Re: Objection to MP08_0244 MOD 1 Modification Request for Mixed Used Development at 23-37 Lindfield Avenue and 11 Havilah Lane, Lindfield

As a resident of Lindfield, I/we wish to lodge an objection against the proposed Modification of the subject development based on the following grounds:

Drawing Title
BASEMENT 3 PLAN

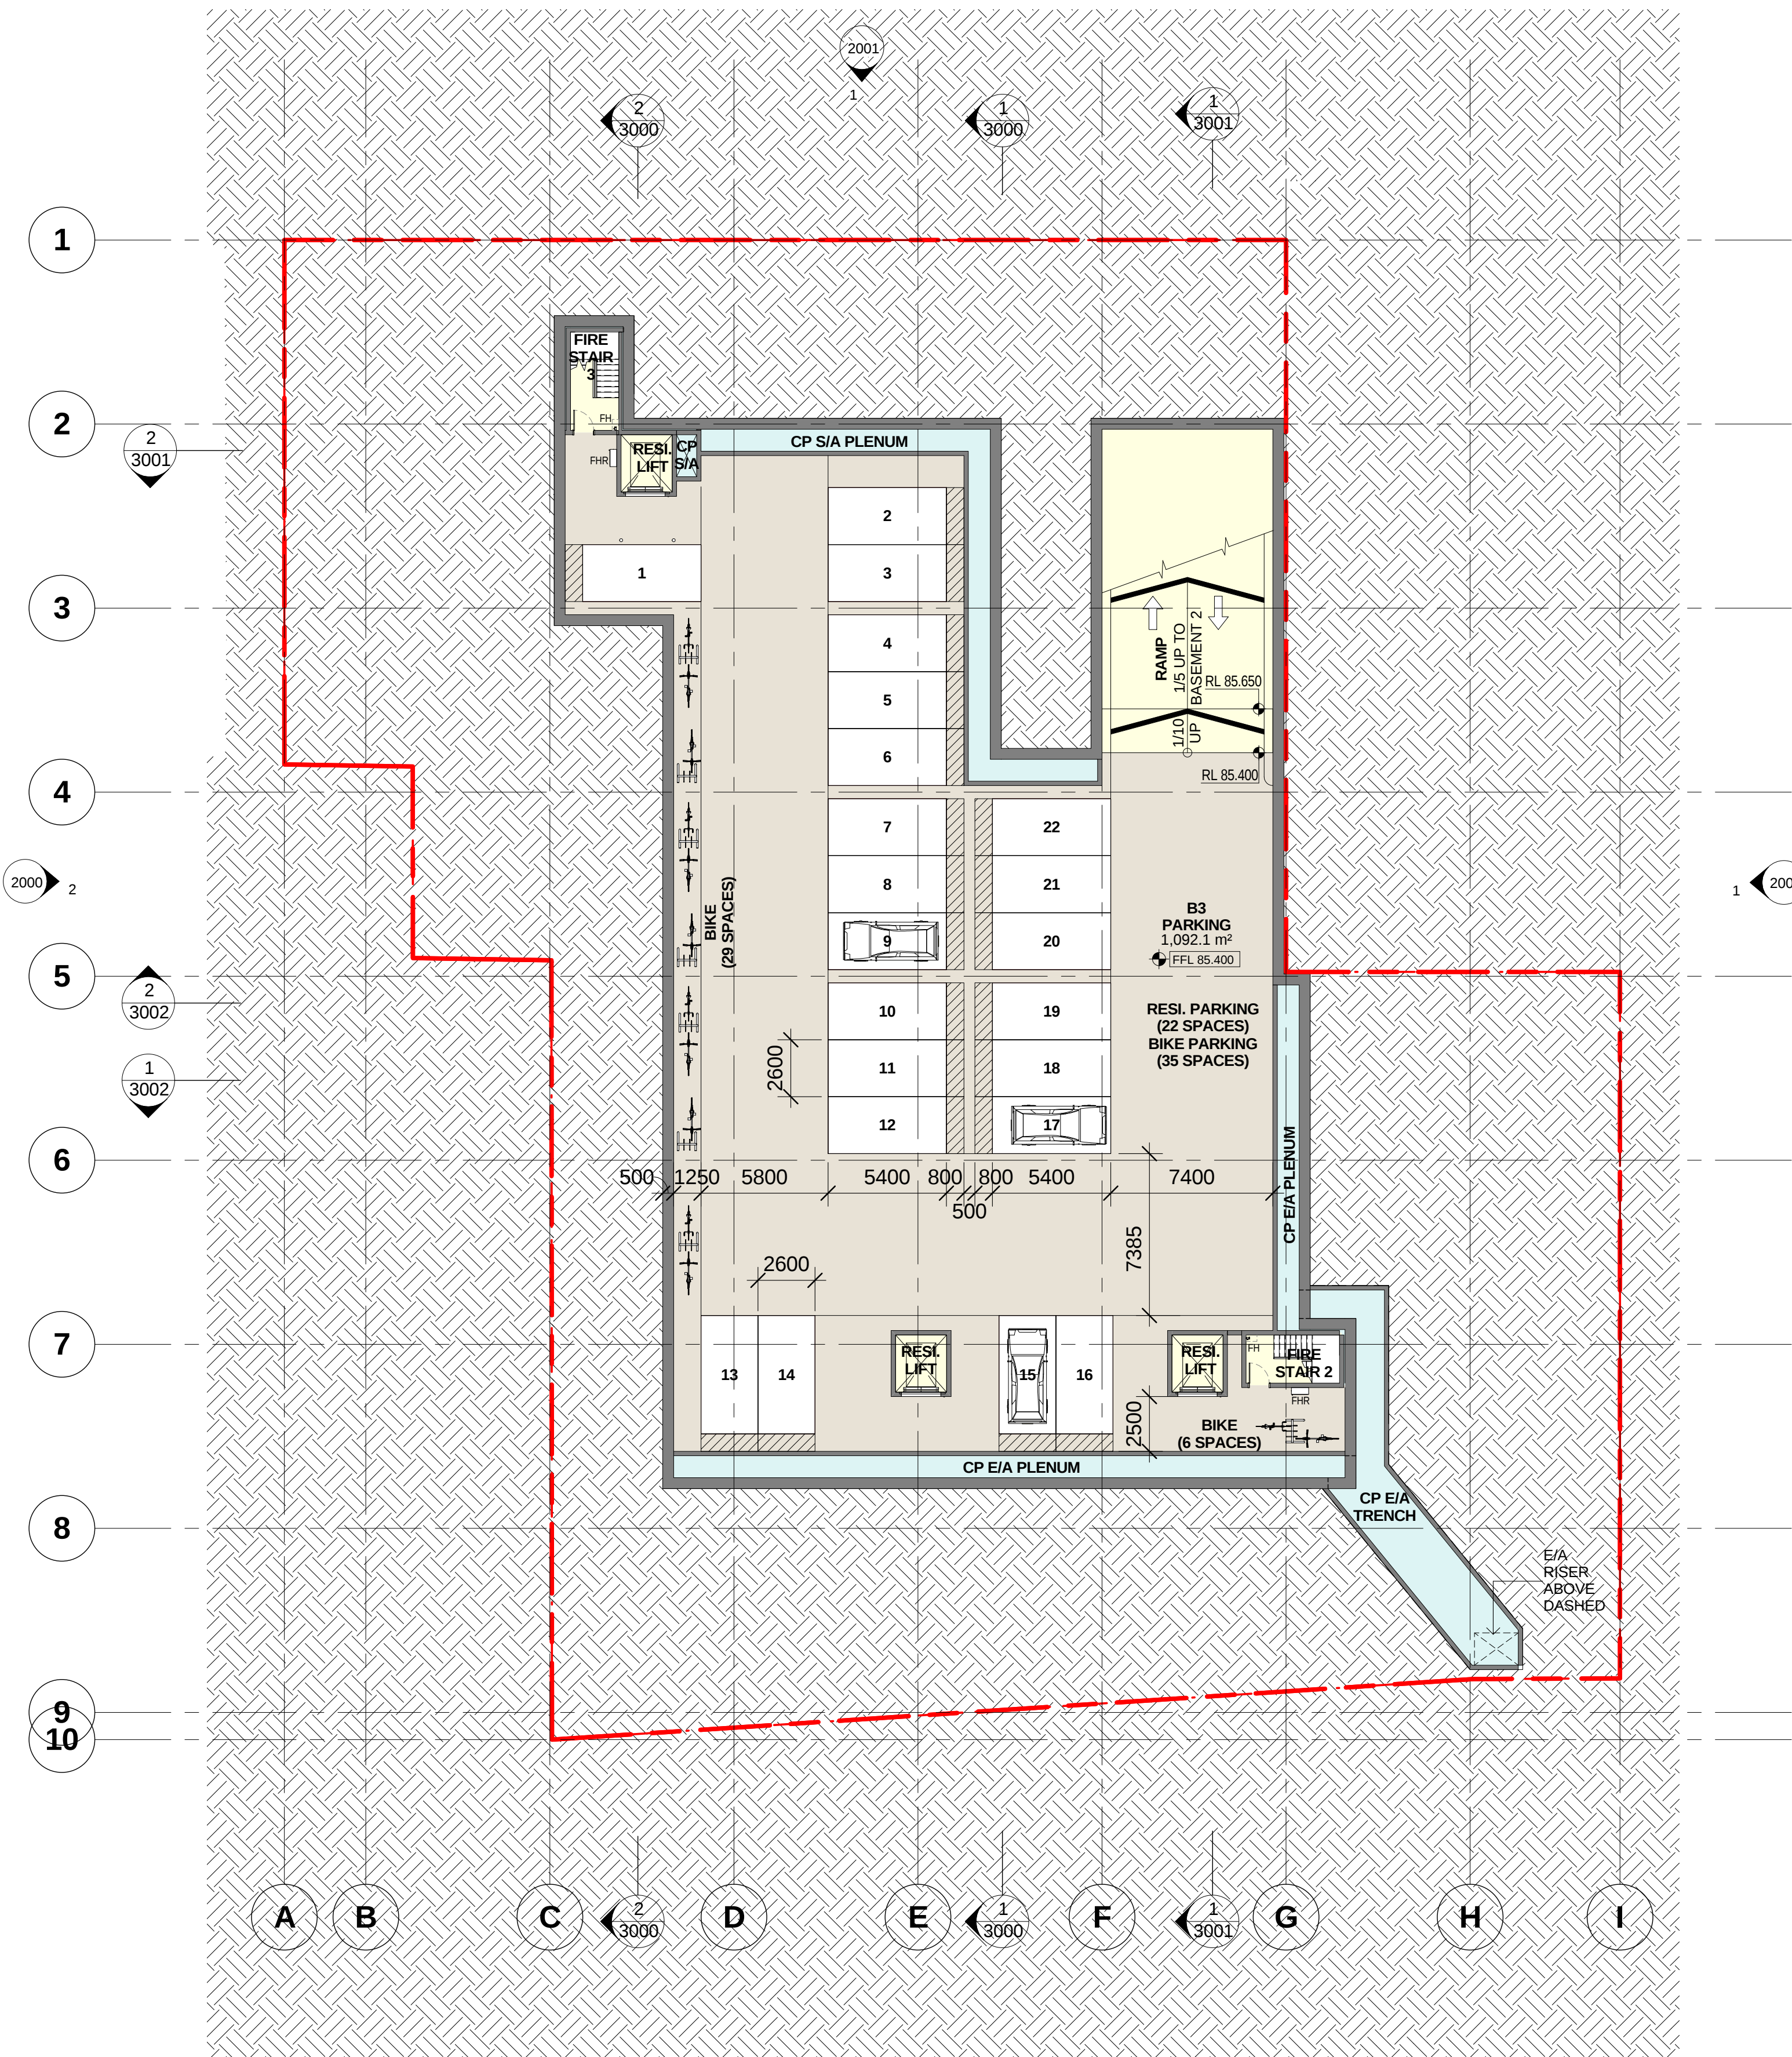
- Car spaces were identified as inadequate for the retail component and this has not been addressed relative to the remaining retail space proposed. The 25 car spaces counted as part of council's car park are also now highly uncertain due to the proposed rezoning and potential redevelopment.

1 HAVILAH LA ELEVATION
2001 SCALE1 : 250

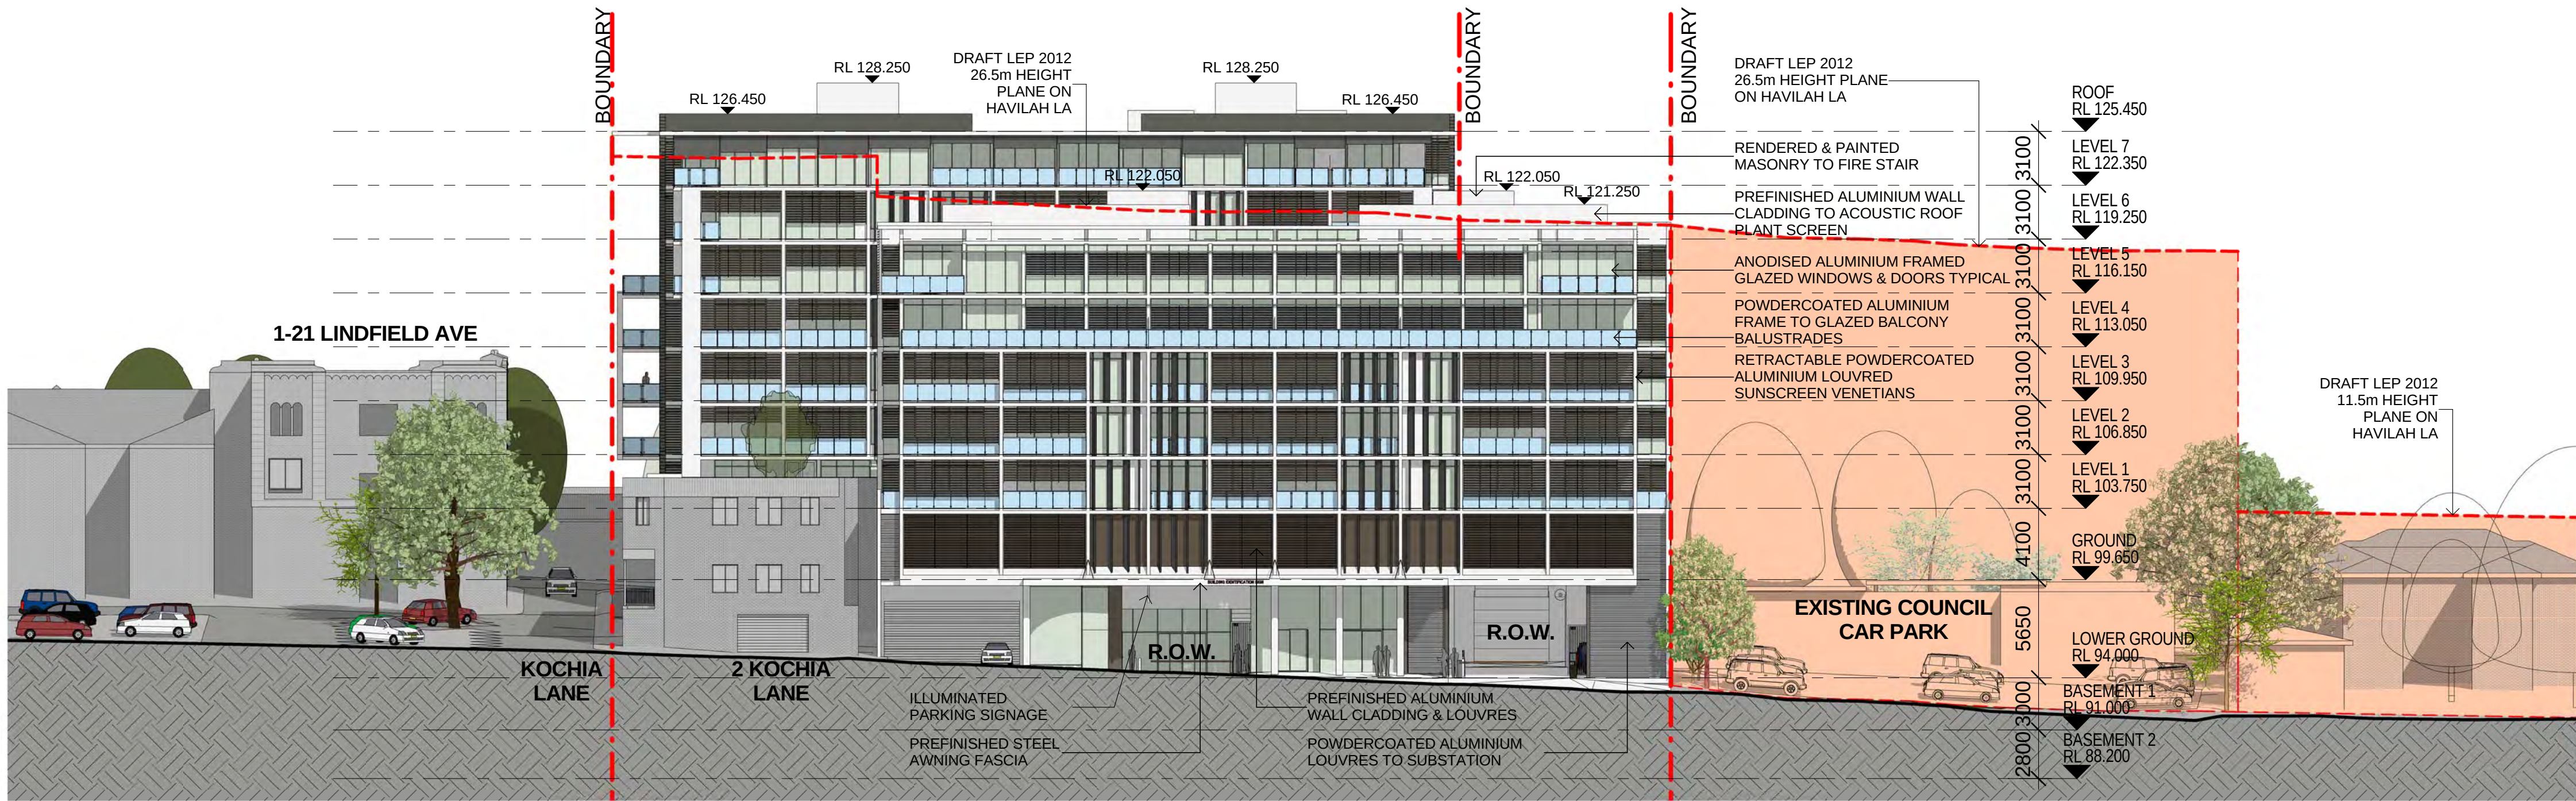
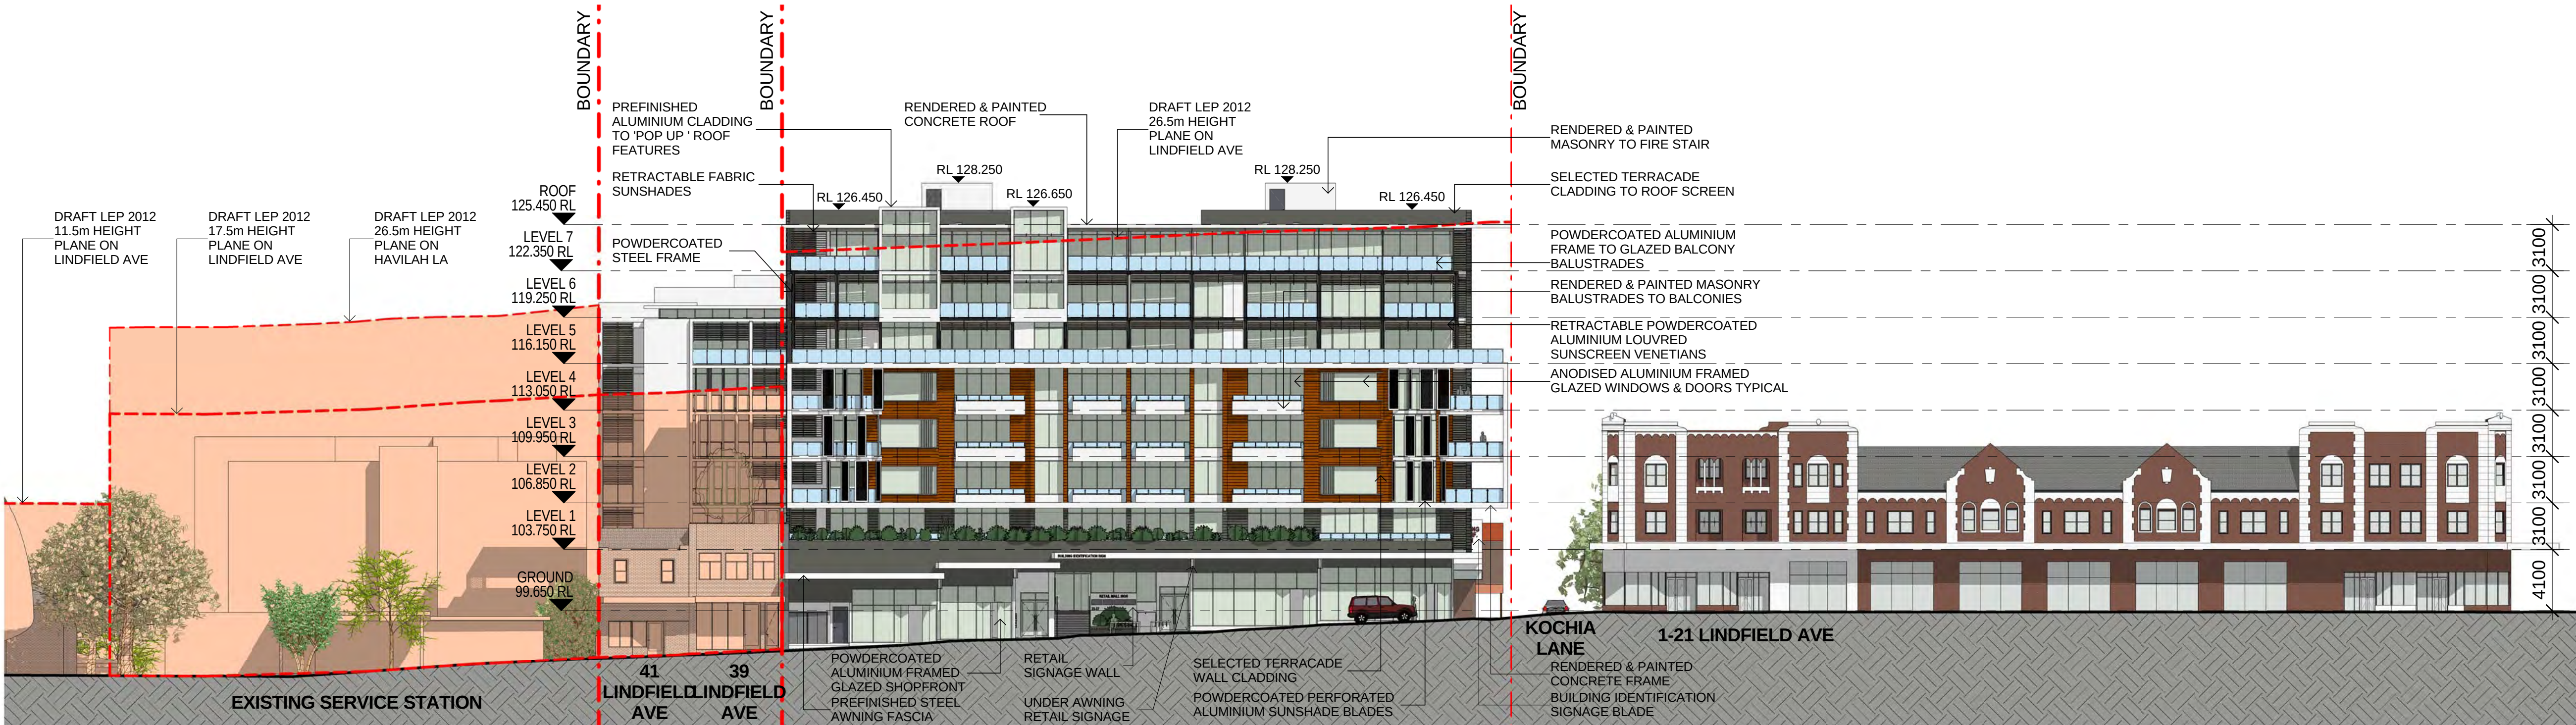
- The increase of an additional storey to both buildings: 8 storeys on Lindfield Avenue and 7 storeys on Havilah Lane creates excessive height and bulk and is out of character with the surrounding buildings, including the heritage listed adjacent building on Lindfield Avenue

- The additional storey (combined with less set back than the approved design) on Havilah Lane now creates privacy concerns for over 40 apartments in the adjacent 8 Havilah Lane, 8 Kochia Lane and 2-8 Milray Street residences
